Appendix F

Pre-Planning Correspondence With ADC

Laura Gibbons, MEng, GMICE
Engineer (Drainage & Coastal)

Client	Wates Redrow
Job	Ford Airfield
Title	Supplementary Soakaway Tests Location Plan

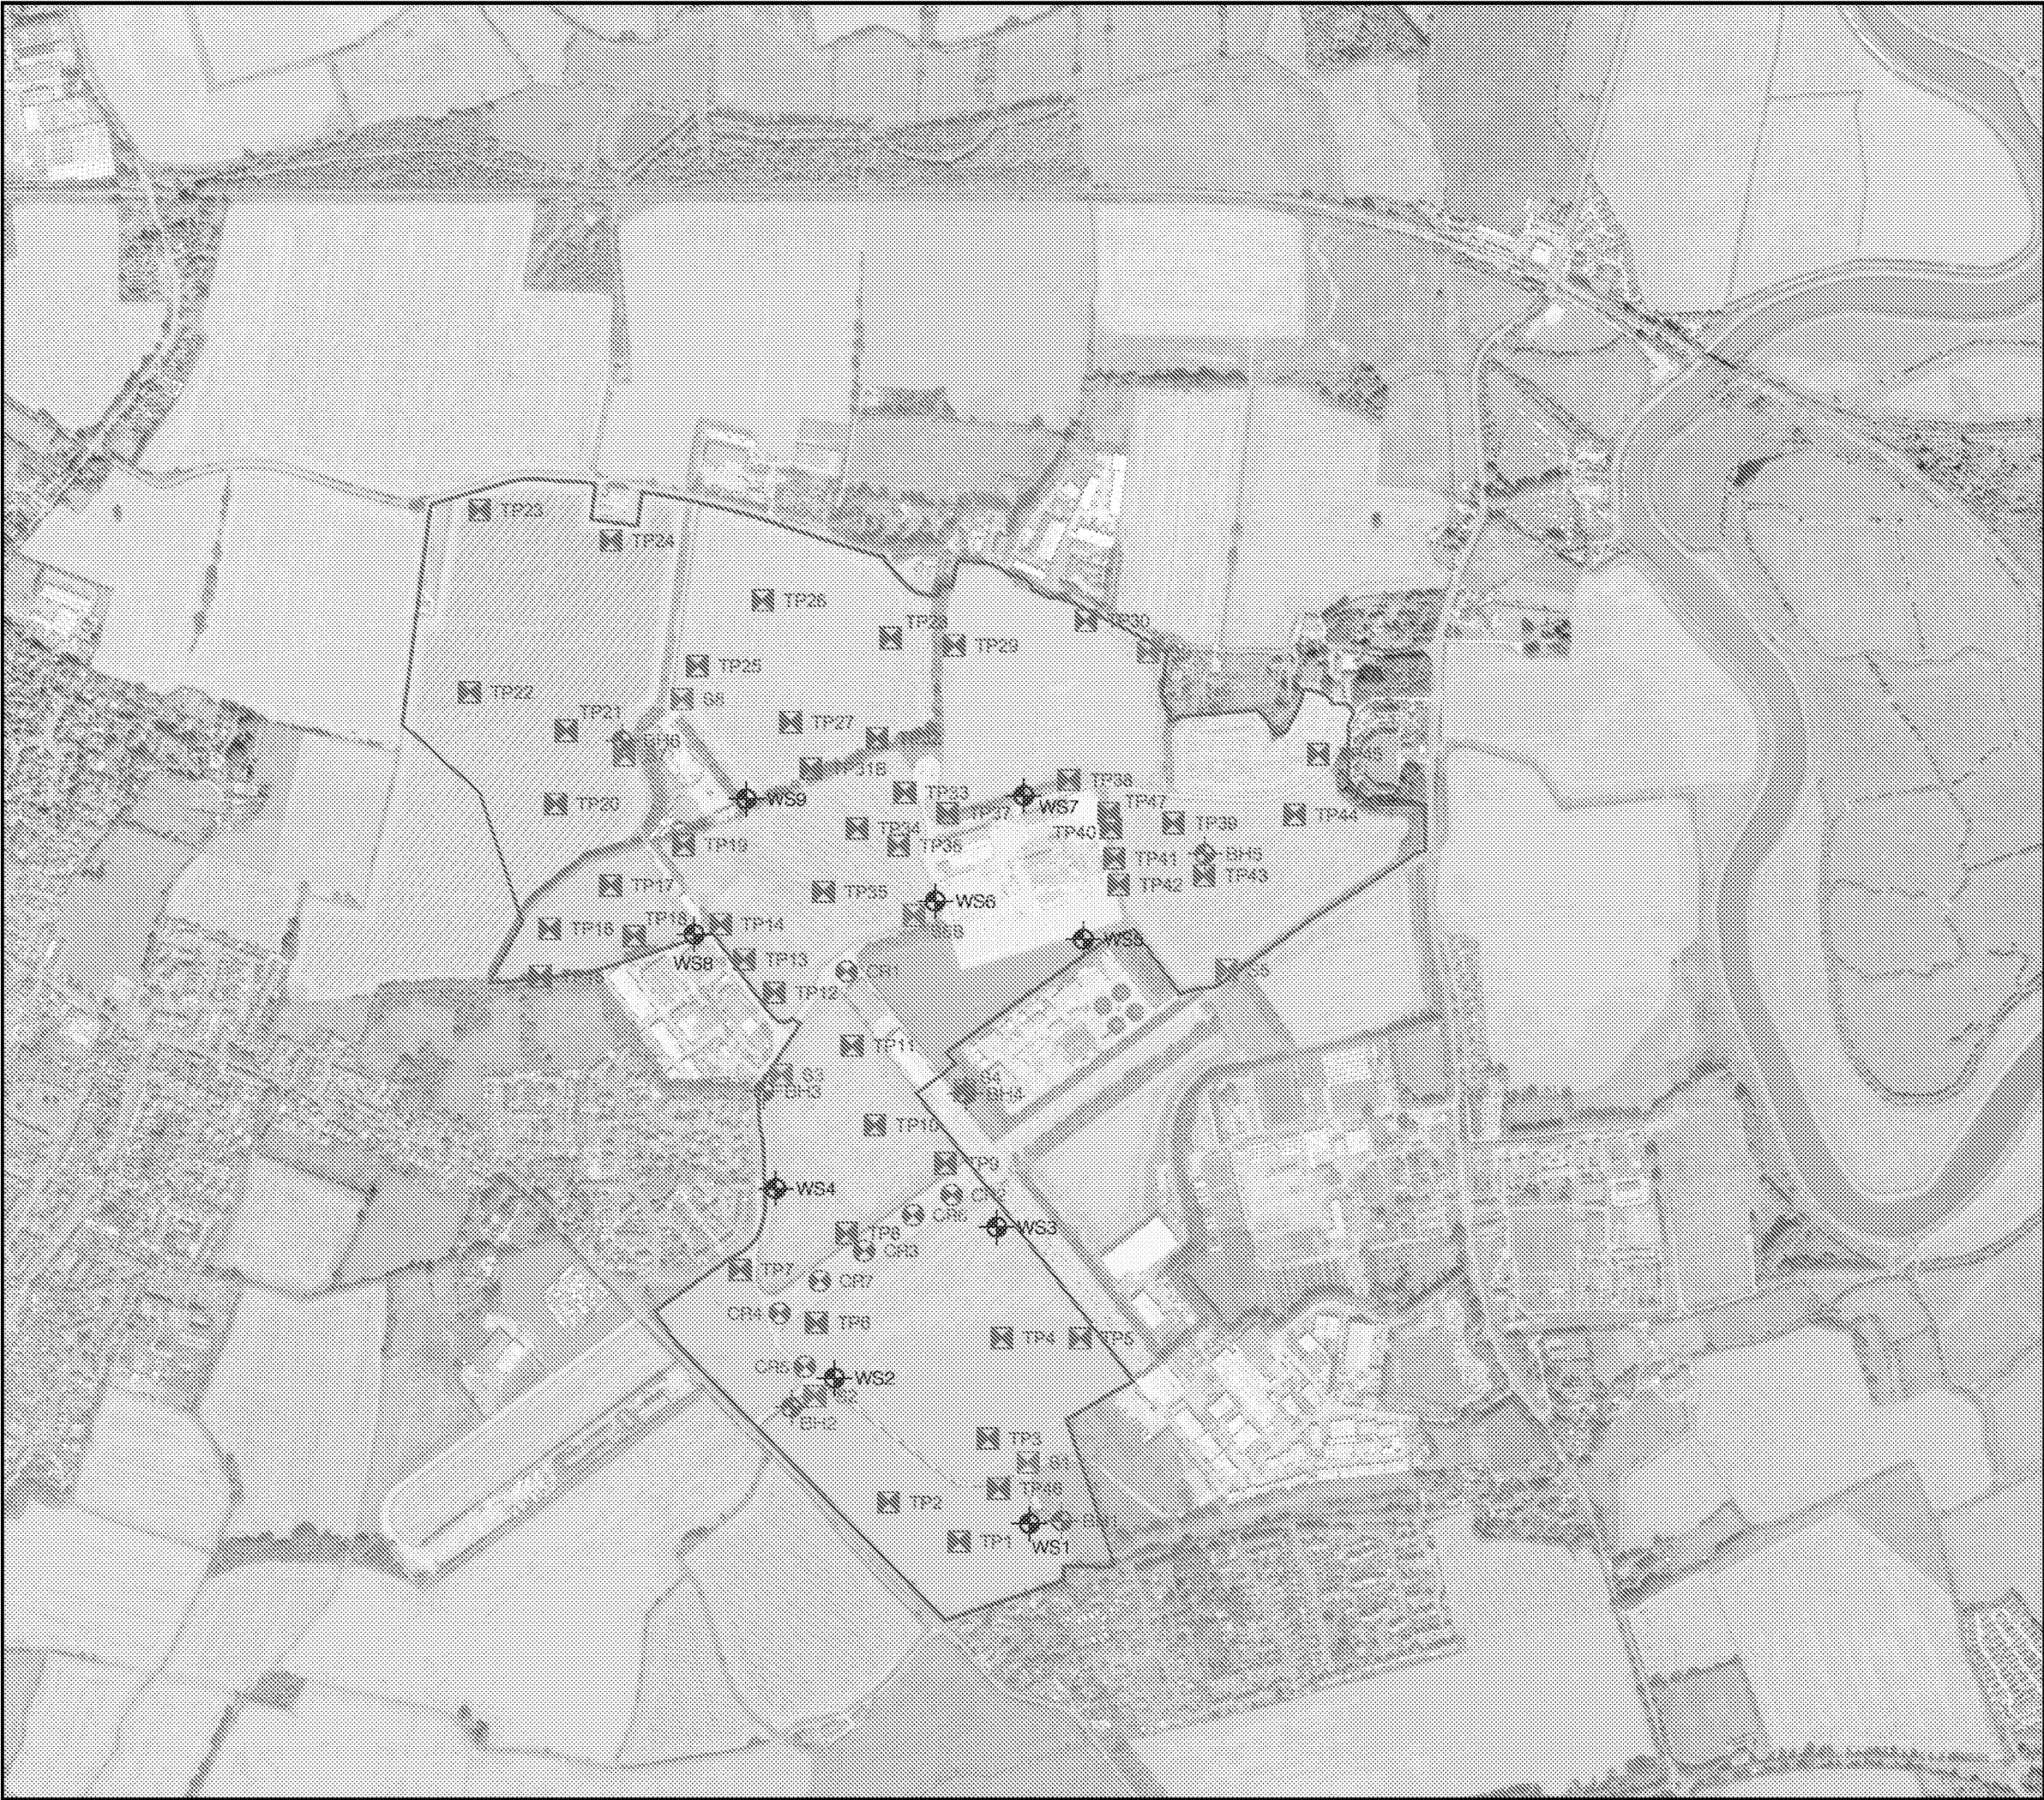
3. Infiltration testing and groundwater monitoring locations are not appropriate to date. Both must be completed at the proposed locations for surface water drainage, yet there is a significant lack of these investigations in the proposed locations of ponds.

4. The locations of monitoring and testing are also very sparse, we would expect far more monitoring and testing to be completed for a site of this size. We would anticipate one shallow infiltration test and one deep infiltration test per small housing parcel. We would also expect a ground water monitoring location within each small parcel.
